# WOODMEN HILLS METROPOLITAN DISTRICT REGIONAL WATER RECLAMATION FACILITY – ADMINISTRATIVE PLOT PLAN

WOODMEN HILLS METROPOLITAN DISTRICT  
REGIONAL WATER RECLAMATION FACILITY  
GRADING & EROSION CONTROL PLAN

**WOODMEN HILLS METROPOLITAN DISTRICT
 REGIONAL WATER RECLAMATION FACILITY
 EXISTING SITE PLAN**
 PCD FILE NO: PPR-17-027

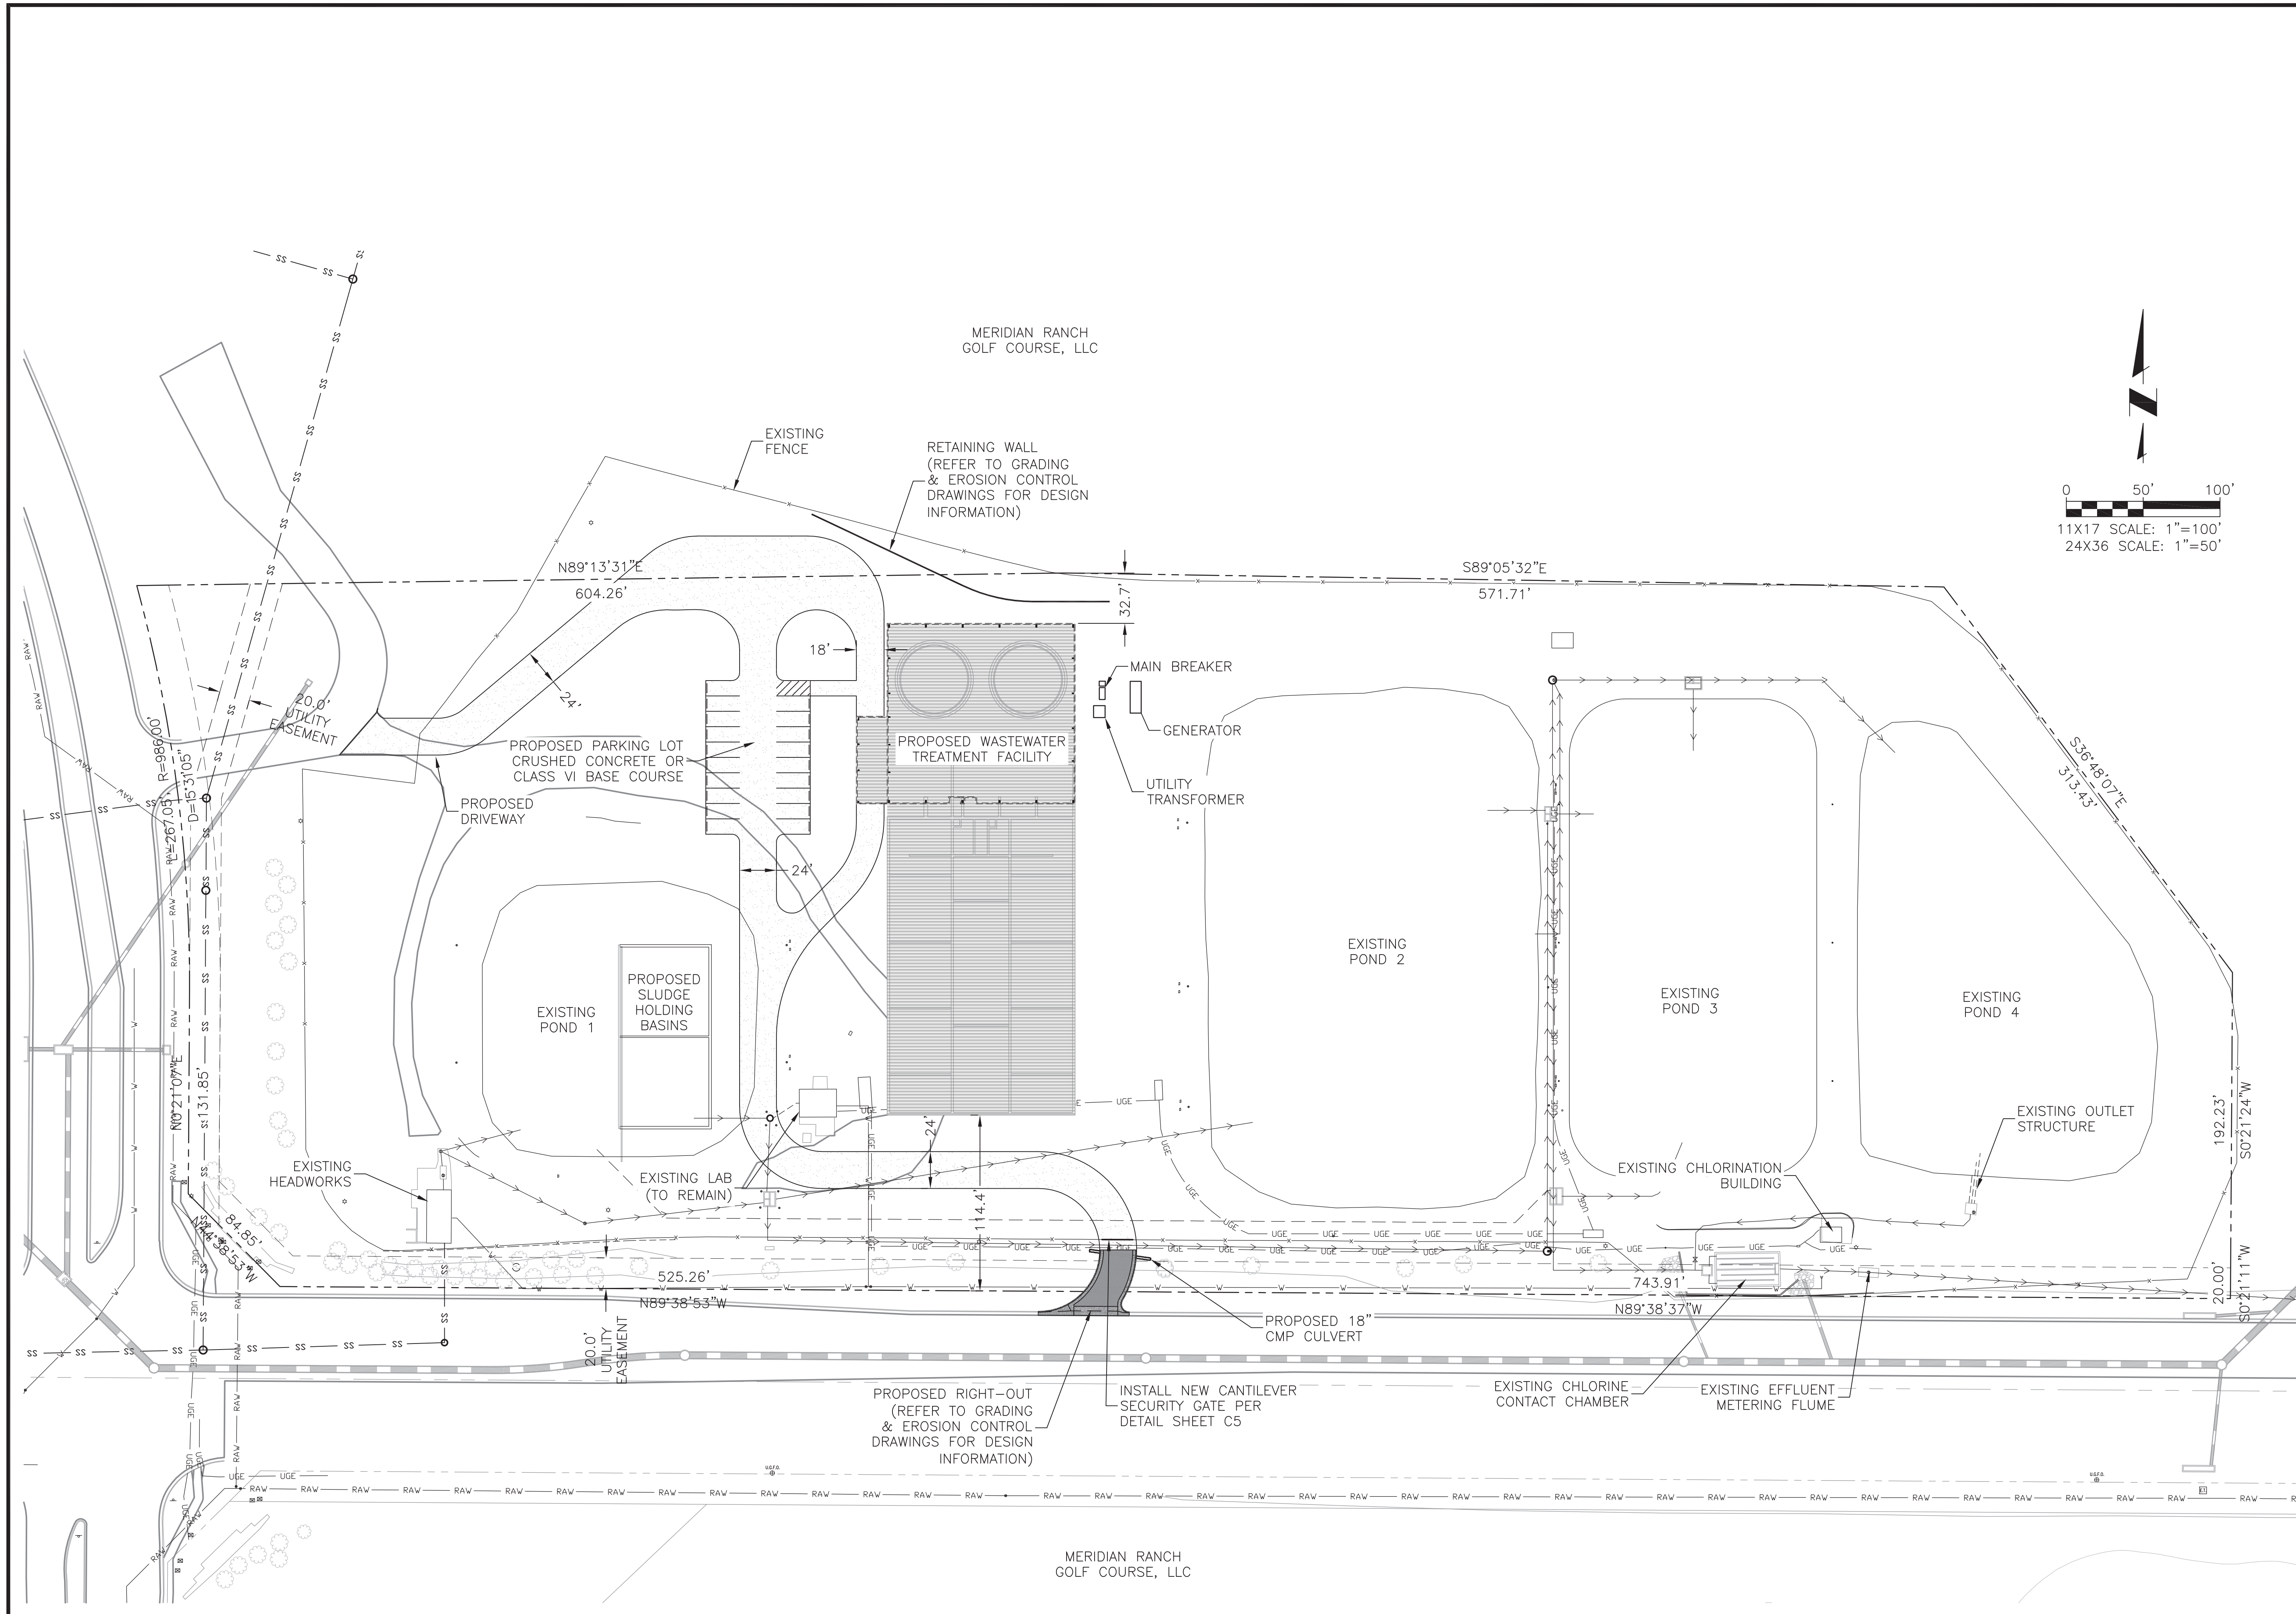
1. Show and label the property line and easements. Label to include the bearing/distance information. Typical comment for sheets C1, C2 & C3.

Aerial imagery is not accepted for a site plan. Please revise throughout.

Add property lines with setbacks

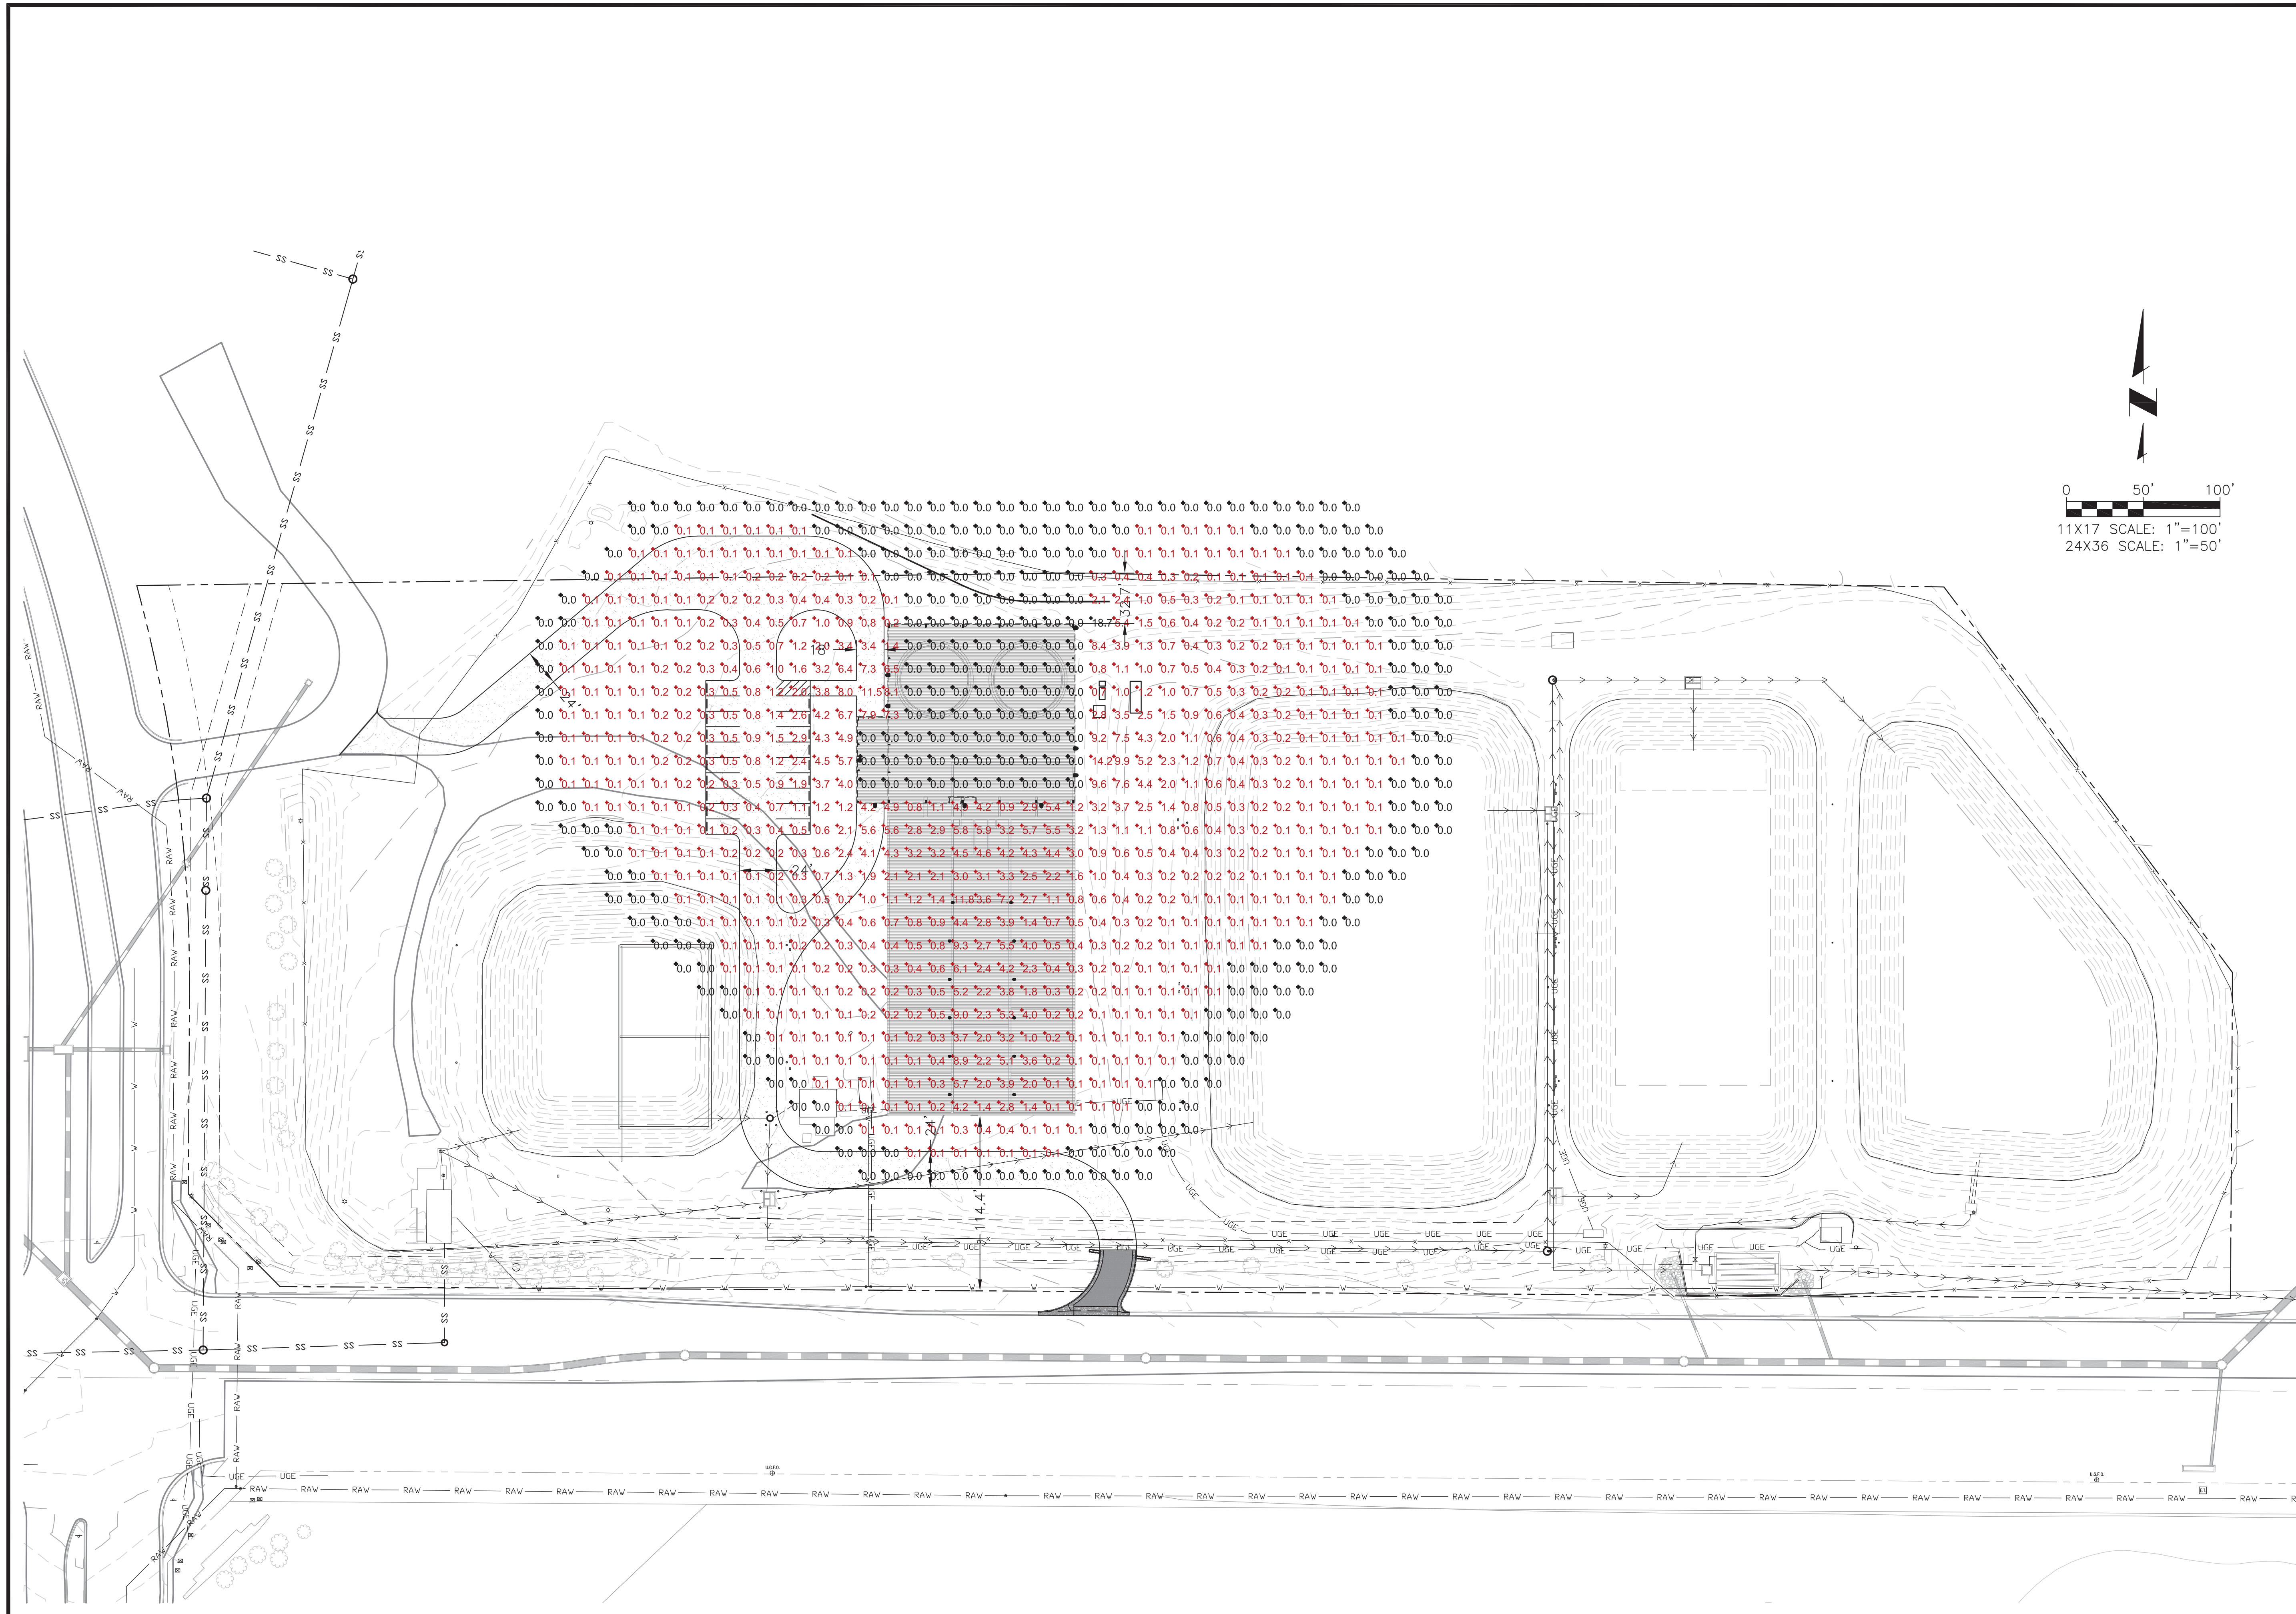
Retaining walls exceeding 4' in ht must meet the setback requirement or seek relief.

Show a retaining wall or regrade at 4: 1 slope.

Please include a parking plan with parking details.

Provide dimension lable for driveway width

Freeze the existing and proposed contours on the proposed site plan.

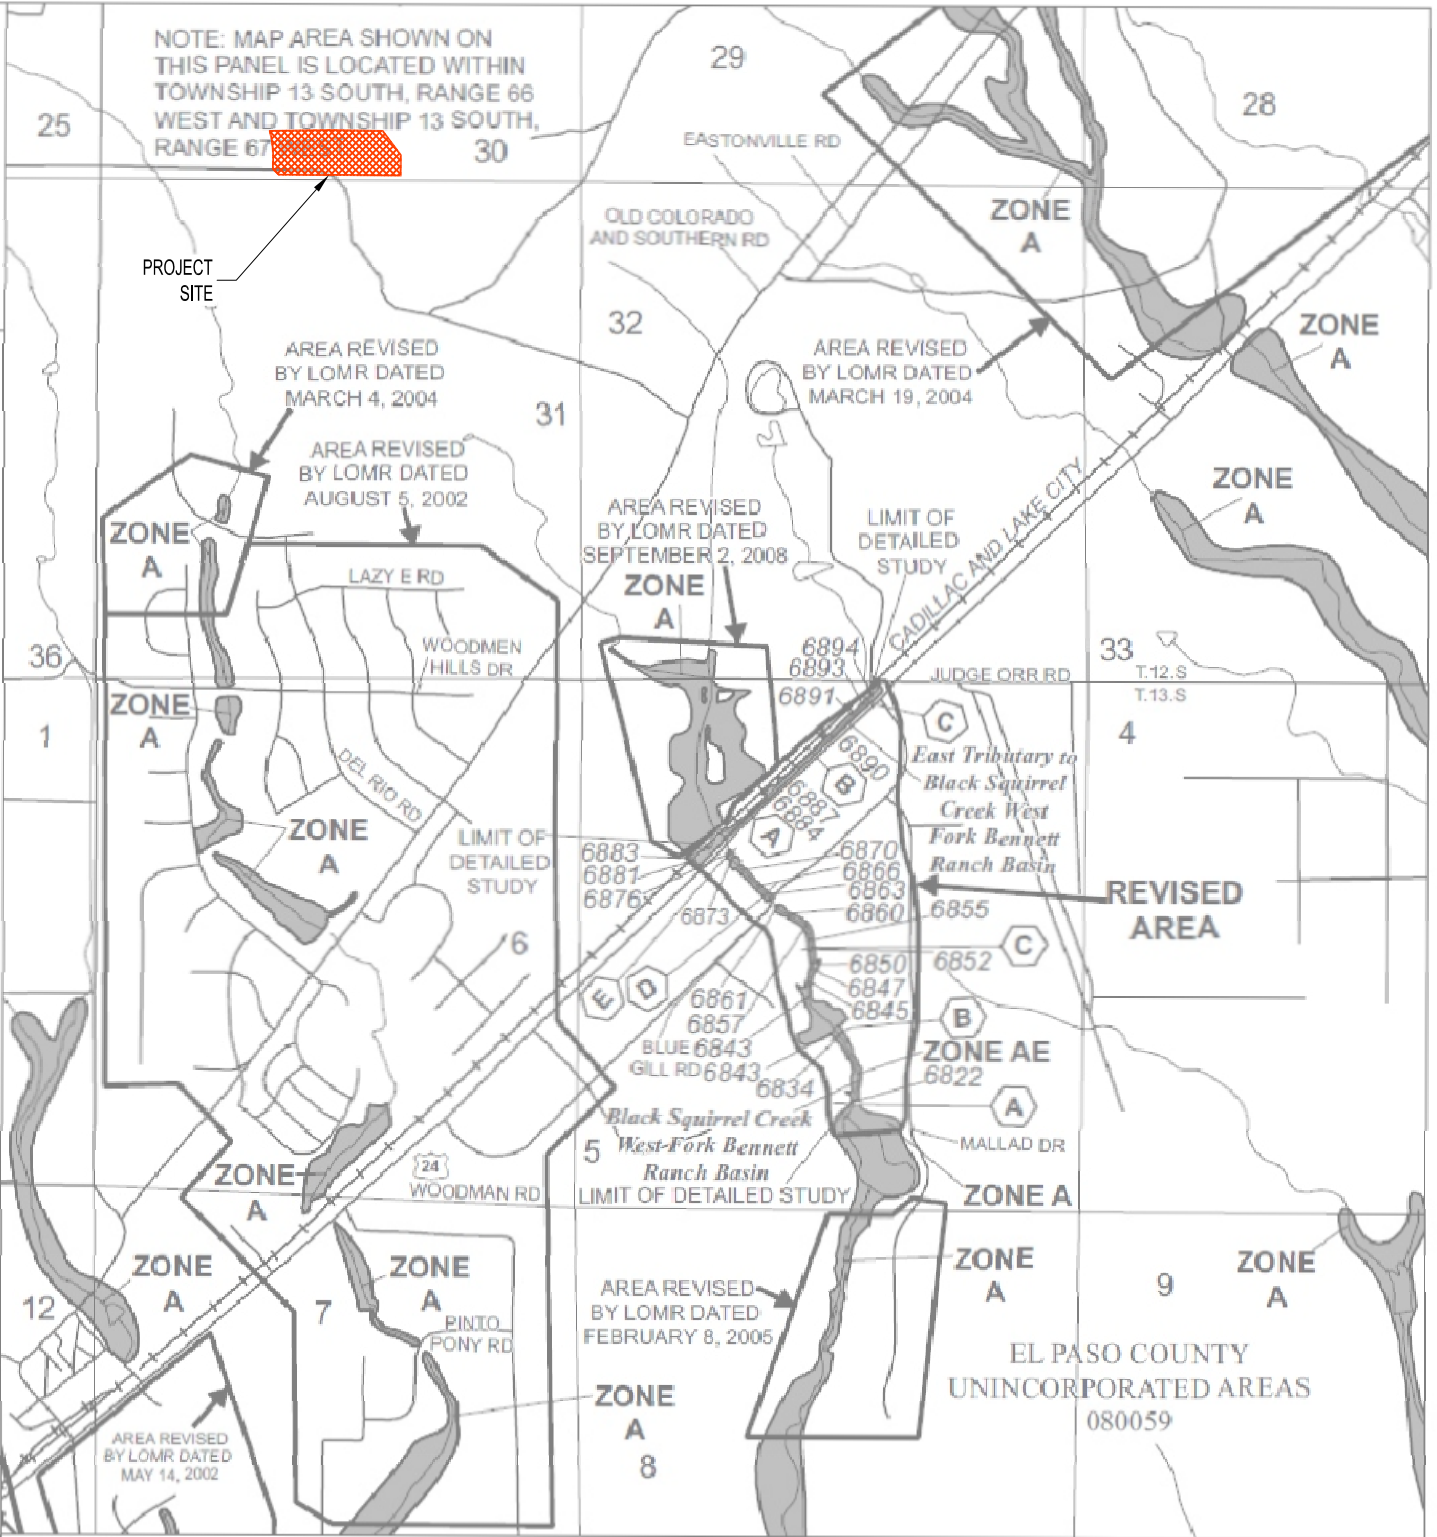
Remove this sheet from the Site Development Plan sheet.

However, the FIRM map needs to be included with the drainage letter.
